Rezoning Transportation Analysis

Petition Number: 2019-177

From: Felix Obregon, PE
fobregon@charlottenc.gov
704-432-5729

Date	Description
01-15-2020	First Review
02-17-2020	Second Review

RZ-1

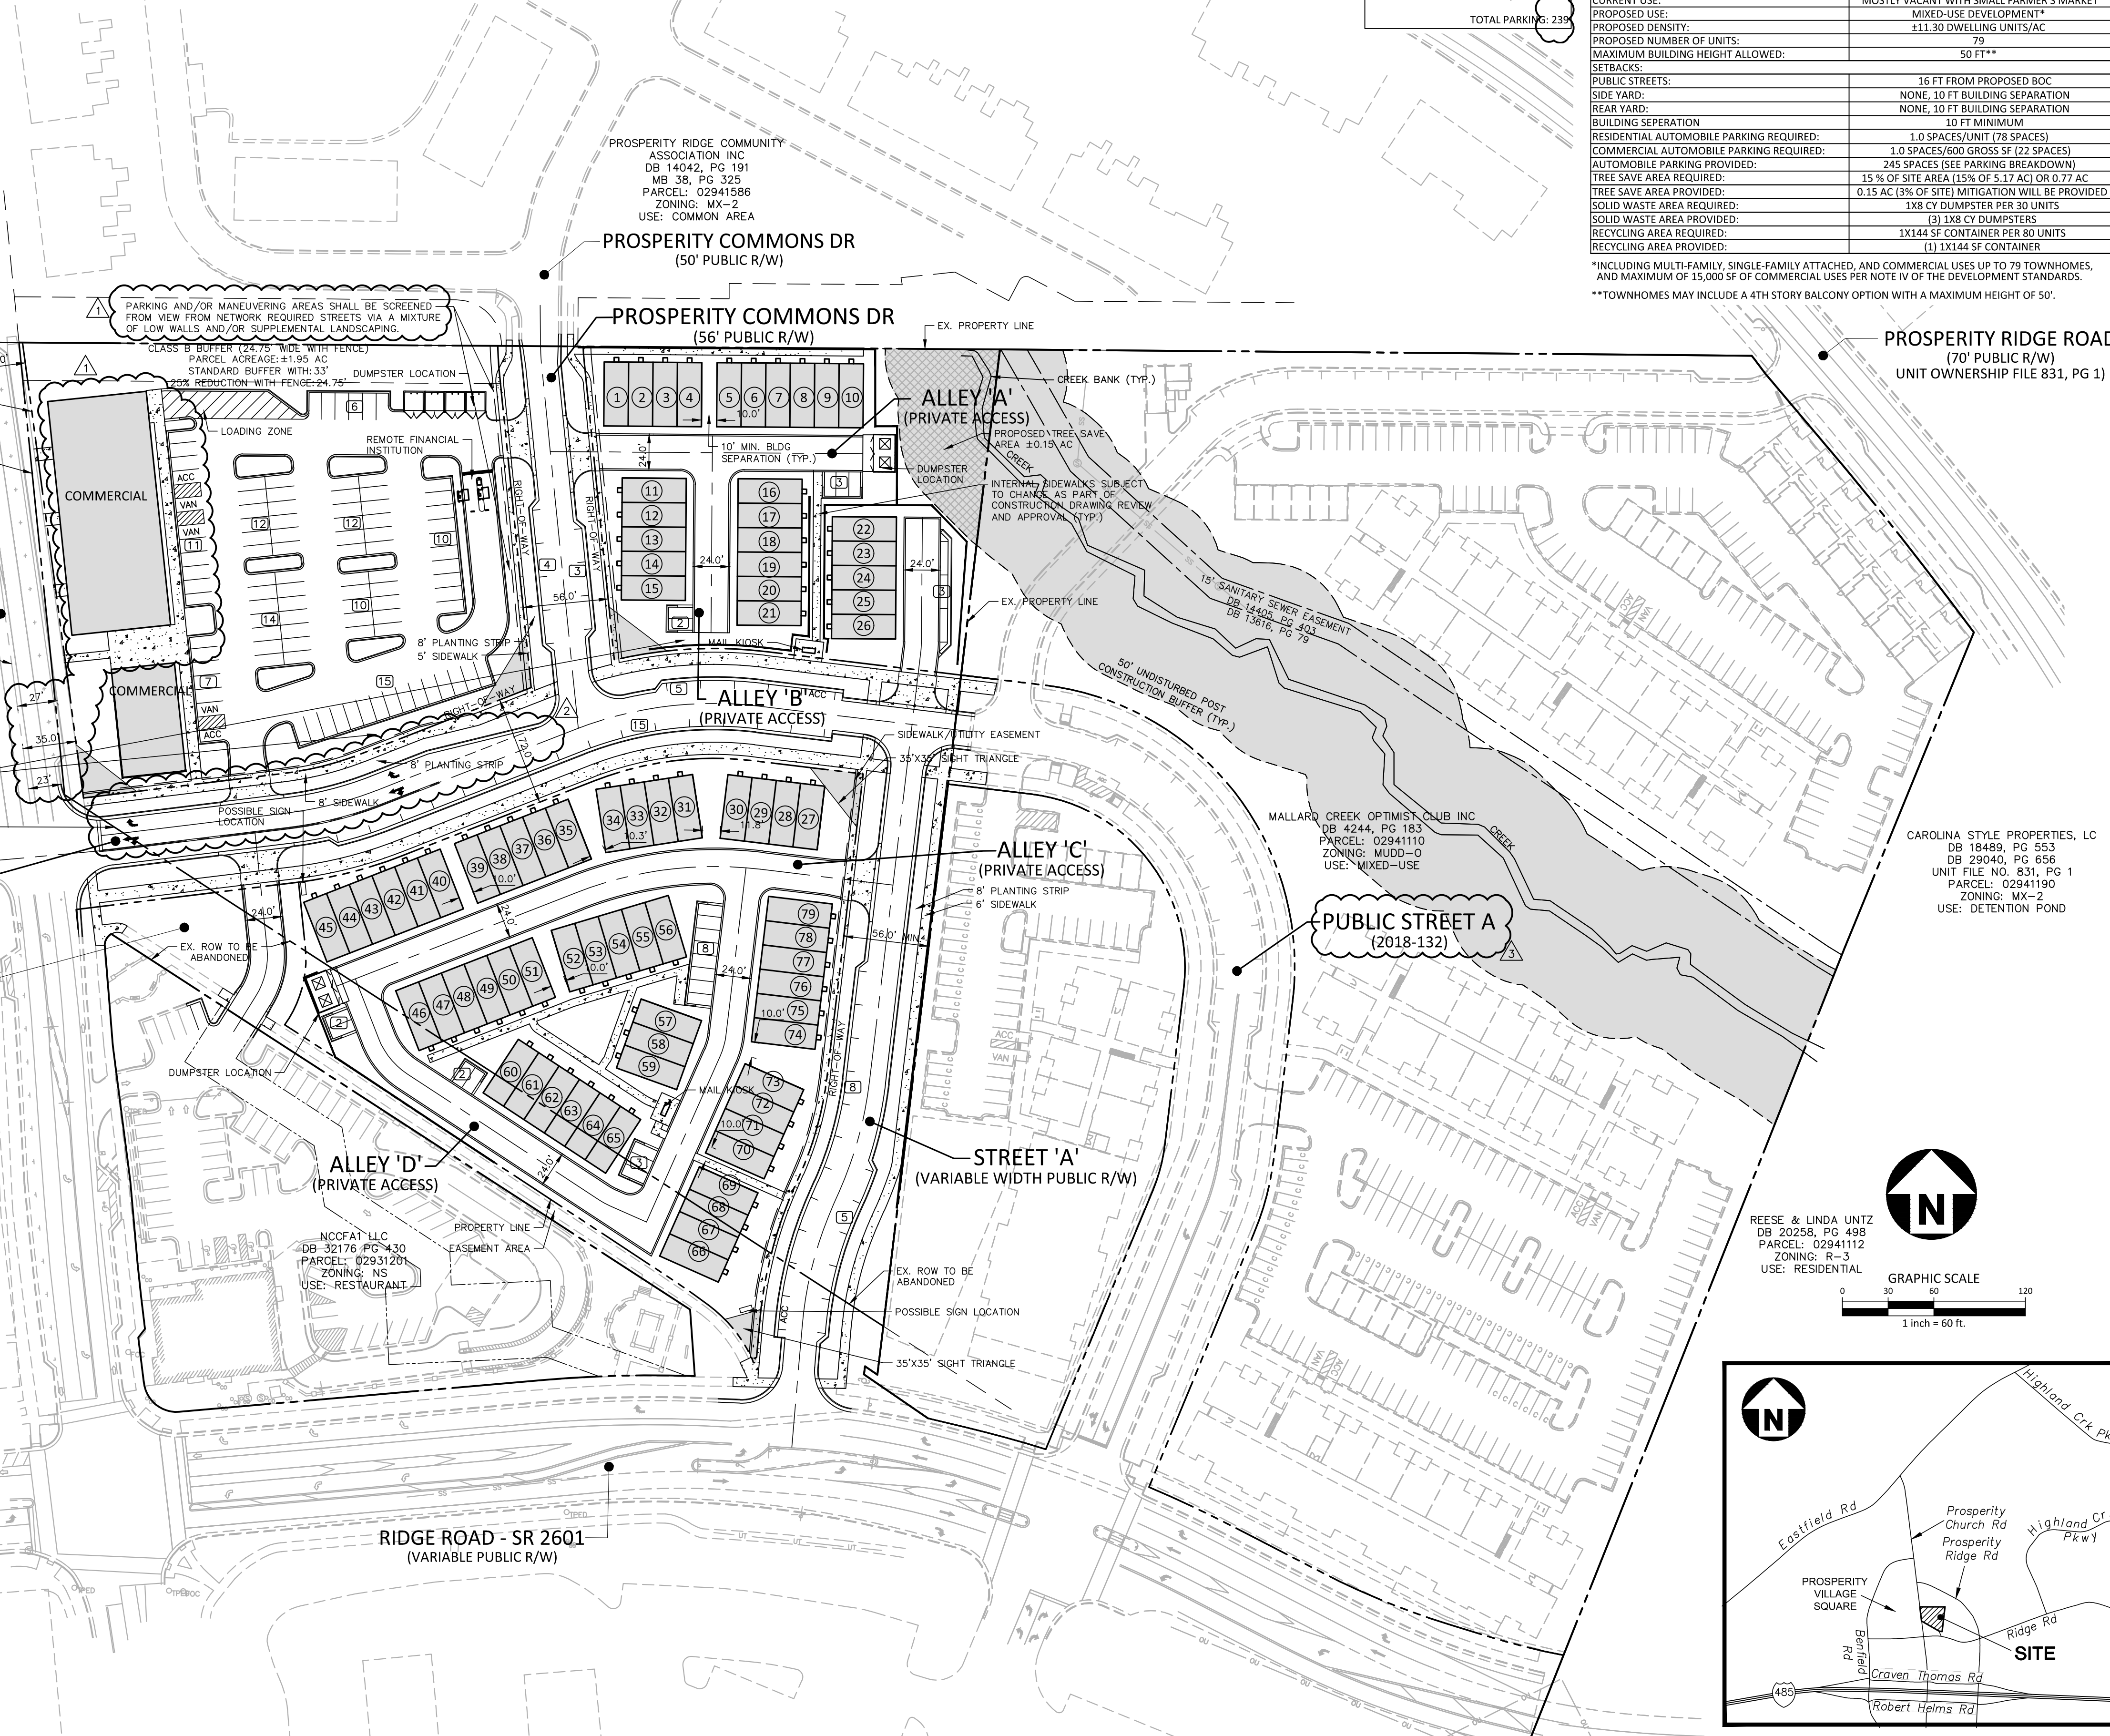
- ~~1. **Curblin**~~ The proposed zoning district has a setback measured from back of the existing or proposed future curblin.
 - ~~a. **Prosperity Church Road:**~~ Location of future back of curb and gutter needs to be installed 18.5' from centerline.
 - ~~b. **Ridge Road:**~~ The future location of curb and gutter is in its existing location.

~~The site plan should show the curb and gutter labeled and dimensioned from the centerline for each road.~~
